**Office of  
Environment  
& Heritage**

Date: 11 July 2017  
Your reference: SSD 7171 & 7112  
Our reference: DOC17/326528  
Contact: Calvin Houlison  
4224 4179

**RE: HUME COAL & BERRIMA RAIL PROJECTS EIS EXHIBITION (SSD 7172 & SSD 7171)**

## ATTACHMENT A – OEH DETAILED COMMENTS – HUME COAL & BERRIMA RAIL PROJECTS EIS – SSD 7172 & 7171

Figure 7.1. Groundwater and surface water sources and zones.

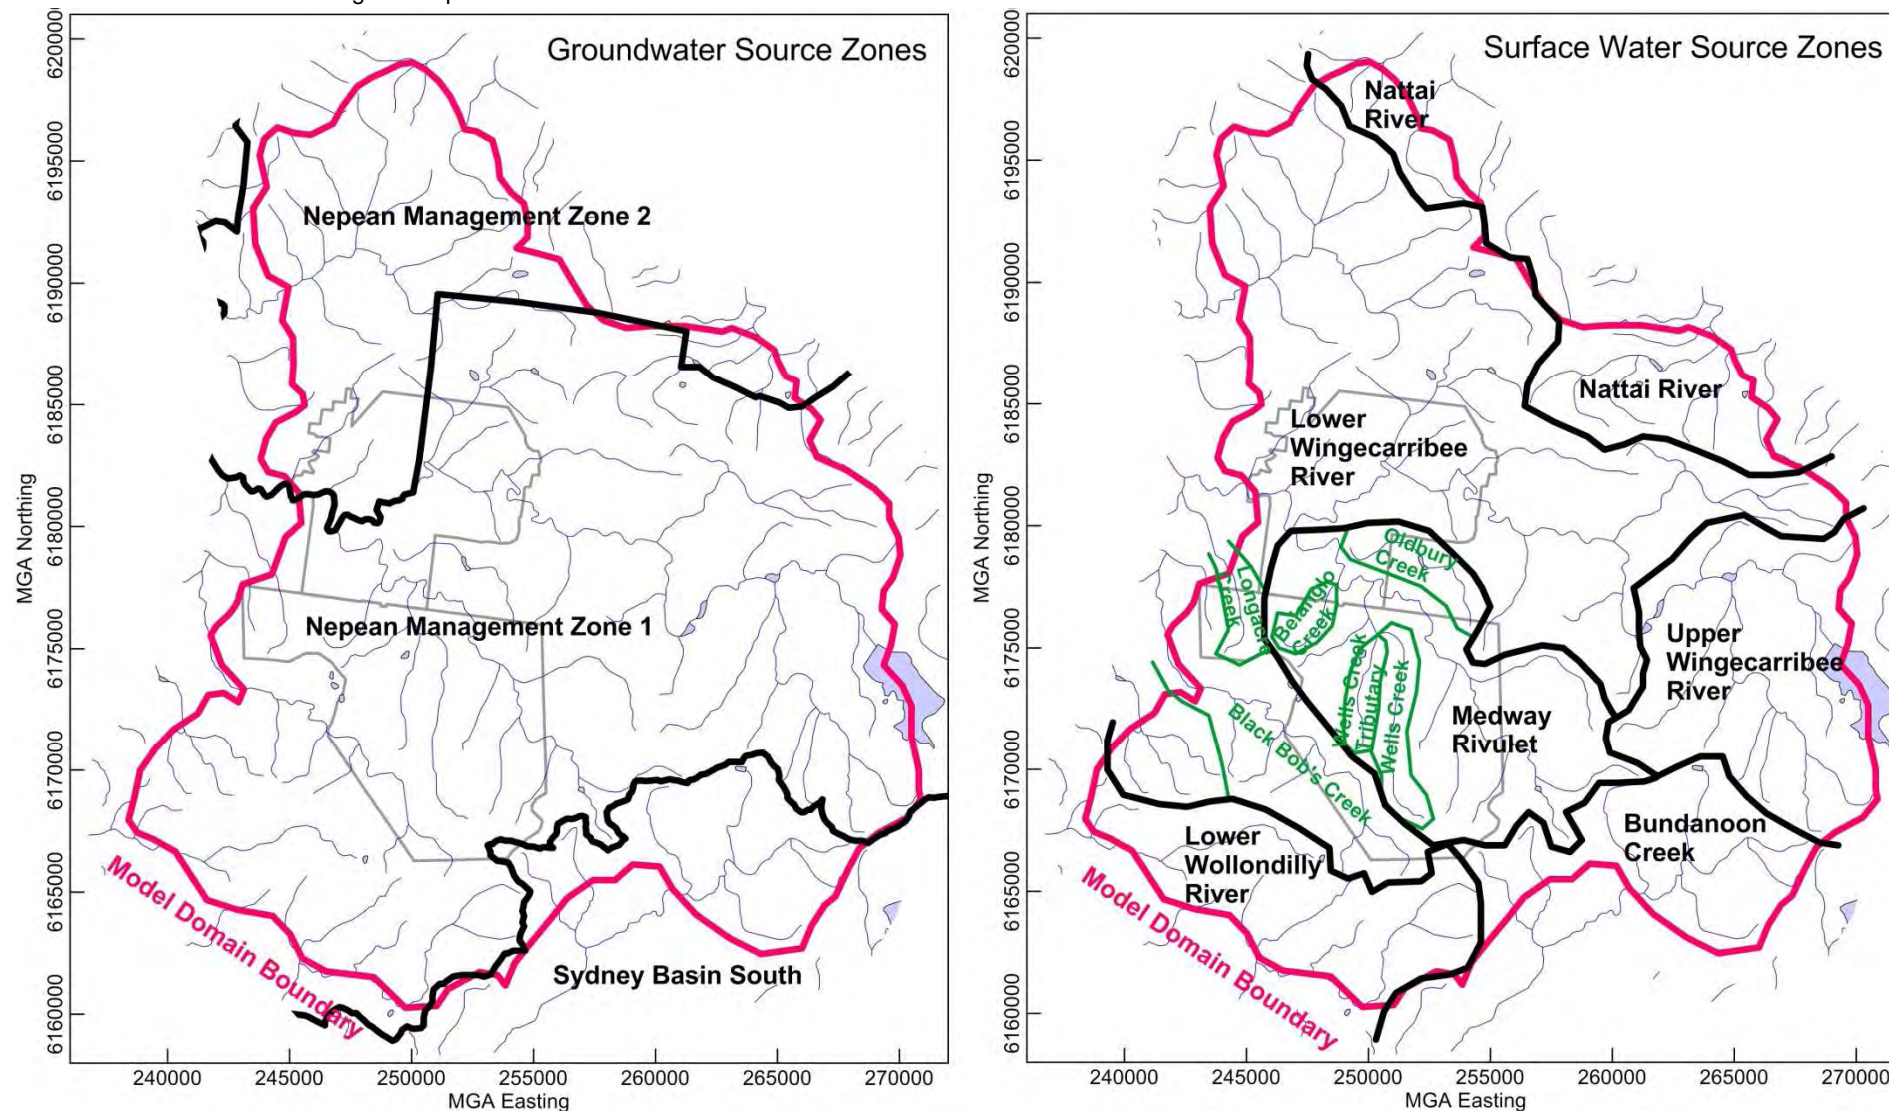
There has not been an assessment of the ecological impacts of water loss/groundwater drawdown to the streams of the area. It is noted that while there are *"make good"* provisions for landholder bores, there are no *"make good"* provisions for any of the streams in the area. Depressurisation of shallow aquifers and subsequent baseflow loss is likely to have the greatest impact on surface water resources.

- 1) Further detailed assessment of the effects of groundwater drawdown and baseflow loss on streams and Groundwater Dependent Ecosystems (GDEs) be provided.
- 2) A monitoring program be put in place to verify the predicted shallow groundwater drawdown and baseflow loss.
- 3) A subsidence monitoring program be put in place for mining in the vicinity of faults.
